**From:** "Murray Donaldson" <mdonaldson@urbis.com.au>  
**To:** <Simon.Truong@planning.nsw.gov.au>  
**Date:** 17/03/2014 11:35 am  
**Subject:** 86-96 & 100 Mount street North Sydney\_ Section 75 Modification for Commercial and Retail Development (MP08\_0241 Mod2)

We write on behalf of Laing O'Rourke Mount Street Pty Ltd (the Proponent) to provide you a response to the North Sydney Council submission in relation to the abovementioned Section 75W Modification. Specifically we wish to respond to Council's comments on the loading dock

drawing  
Plan - B1 Level

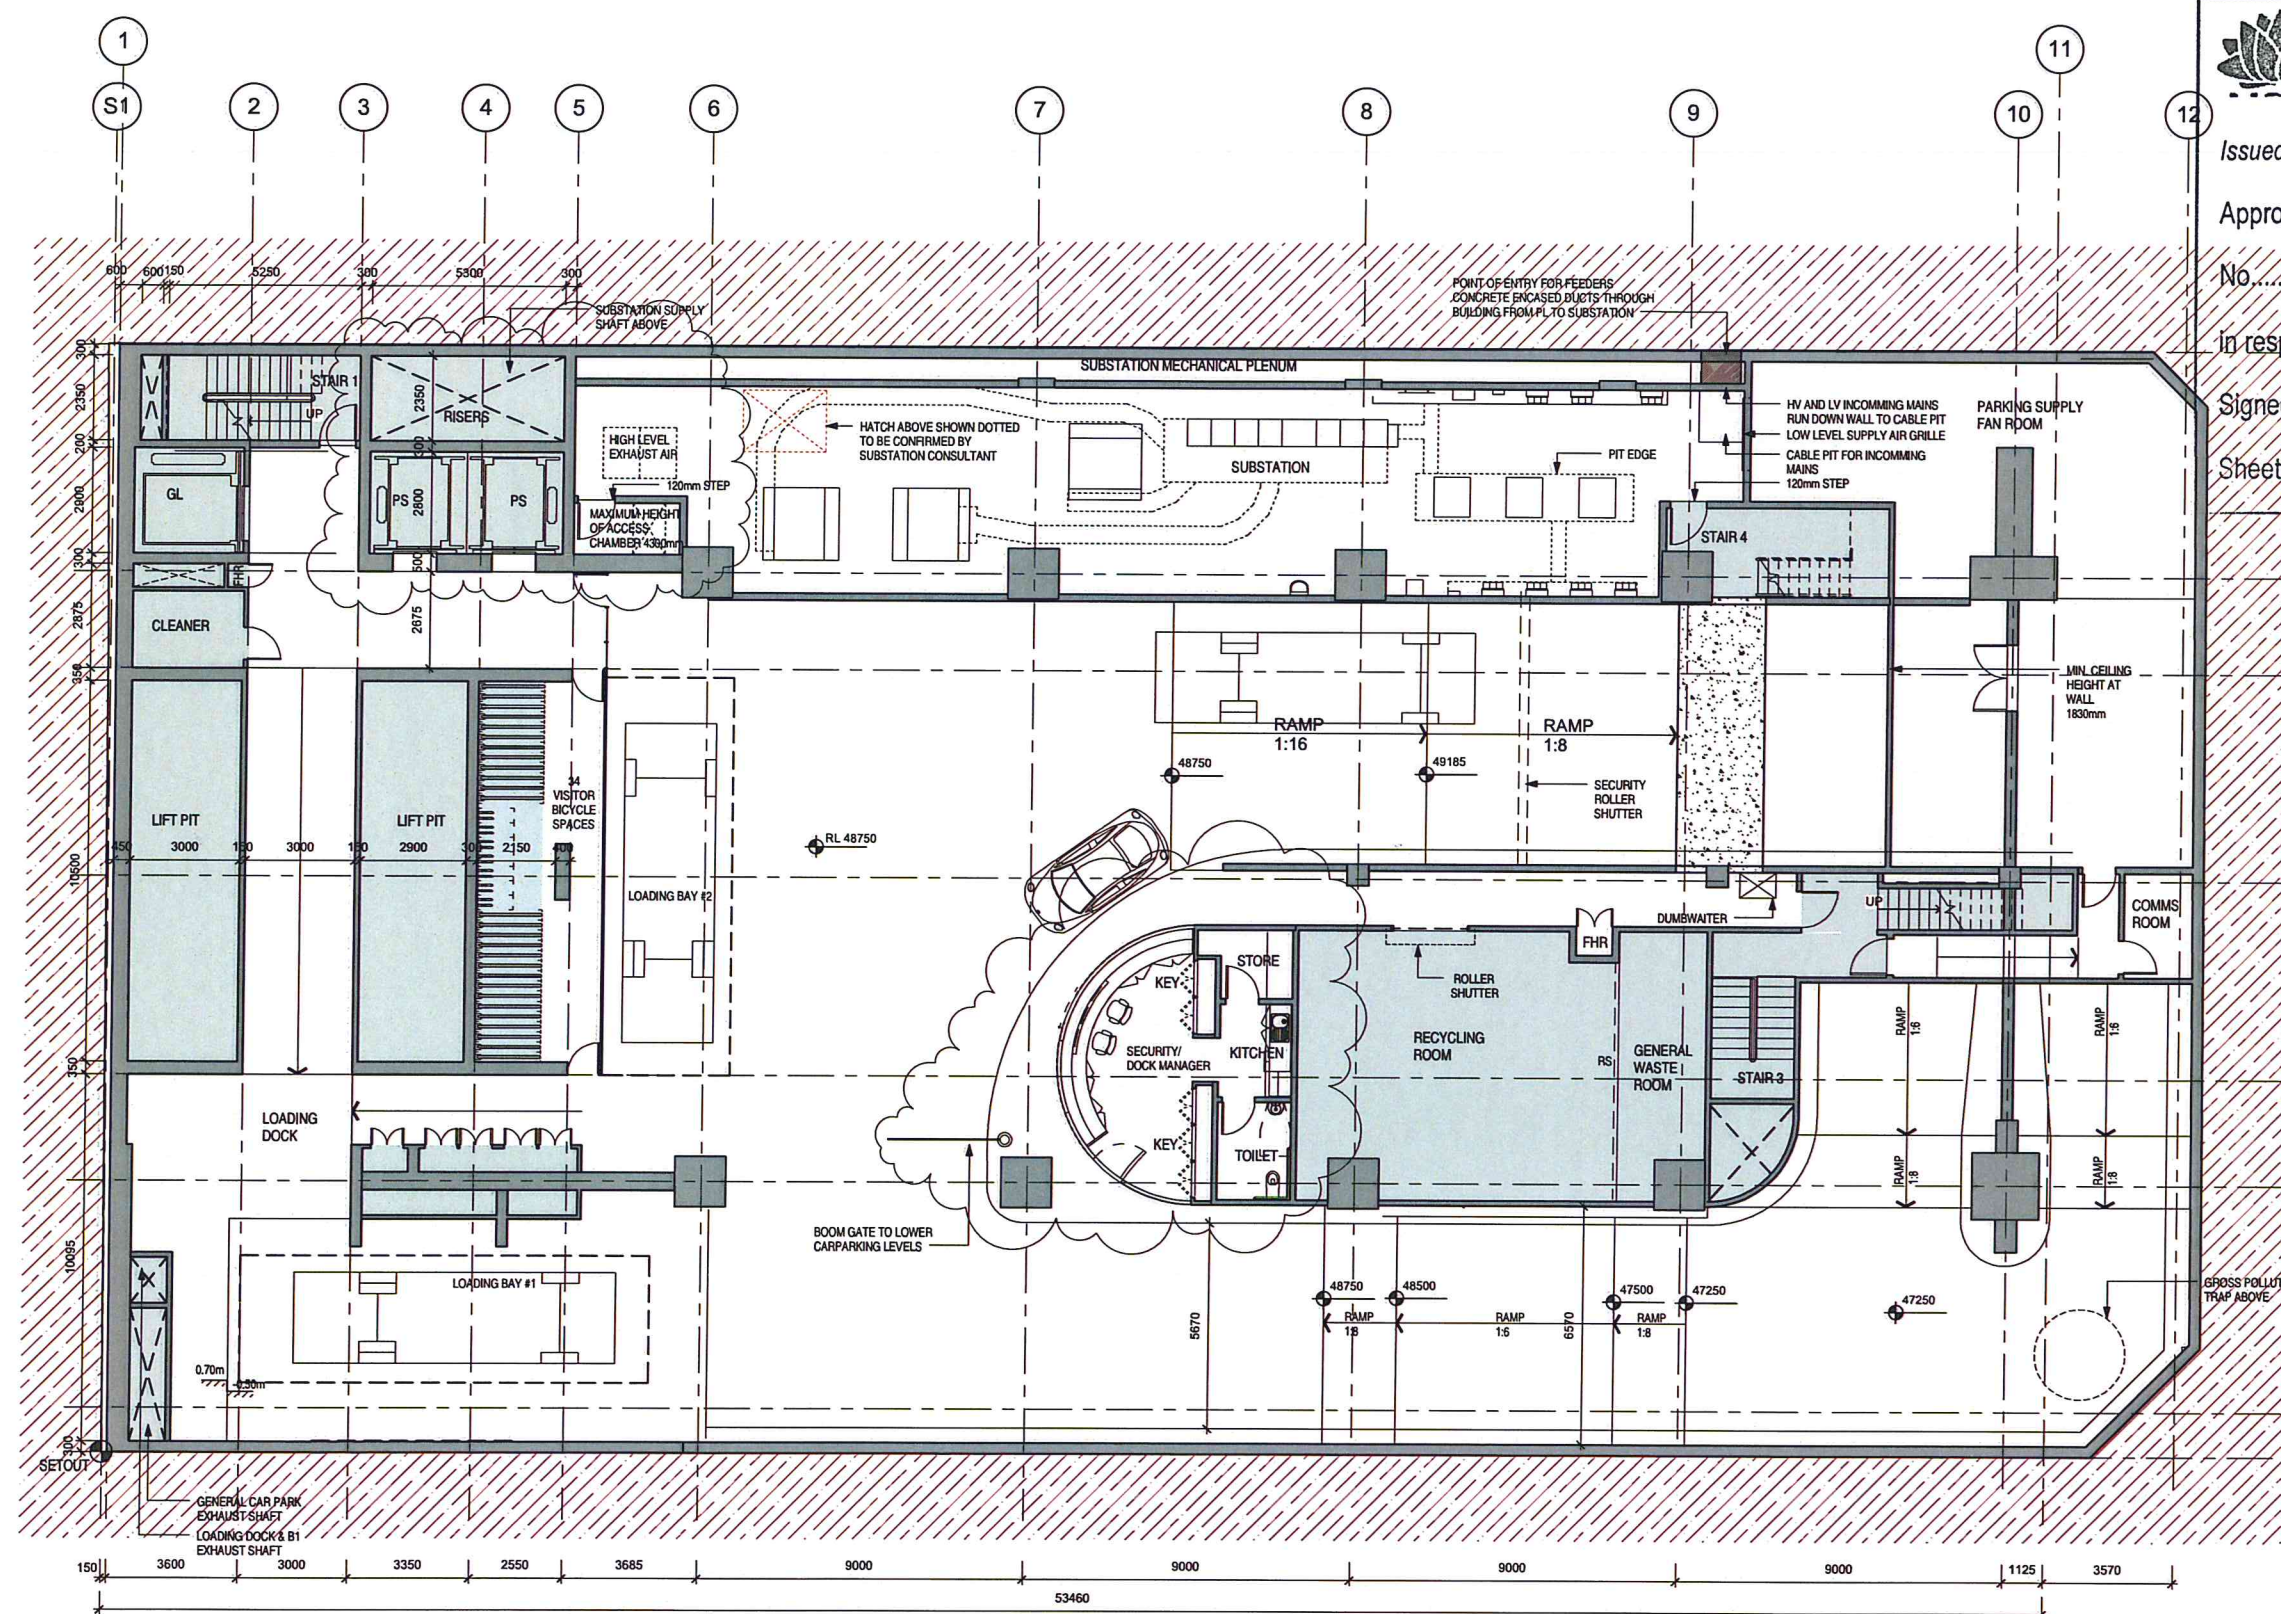
With regard to the new proposed loading dock on B1, there are serious concerns with its compliance with 2890.2. To address these concerns the following condition should be imposed:

§ That the design of the loading docks in B 1, including dock length, width, height and aisle widths be compliant with 2890.2.

§ That further plans showing an AutoTURN or AutoTRACK simulation of the largest possible vehicles likely to access the loading dock (Medium Rigid Truck as defined in 2890.2) entering and leaving each loading dock in a forwards direction.

The loading dock has been reviewed by Colston Budd Hunt & Kafes traffic engineers for the Proponent having regard to the relevant Australian Standards. The loading dock complies with AS2890.2 with the exception of the vehicle clearance height. The project approval includes a consent condition B39 that nominates a clearance of 3.6m. The proposed clearance height is 4.2m at scheme design, which complies with Condition B39. Strict compliance with AS2890.2 requires a clearance height of 4.5m. A height of 4.5m will severely compromise the ground plane above which has an access ramp. Furthermore, a clearance height of 4.5m will have an excessive impact on the Walker Street streetscape and will compromise pedestrian amenity. We request condition B39 (4) be maintained as approved.
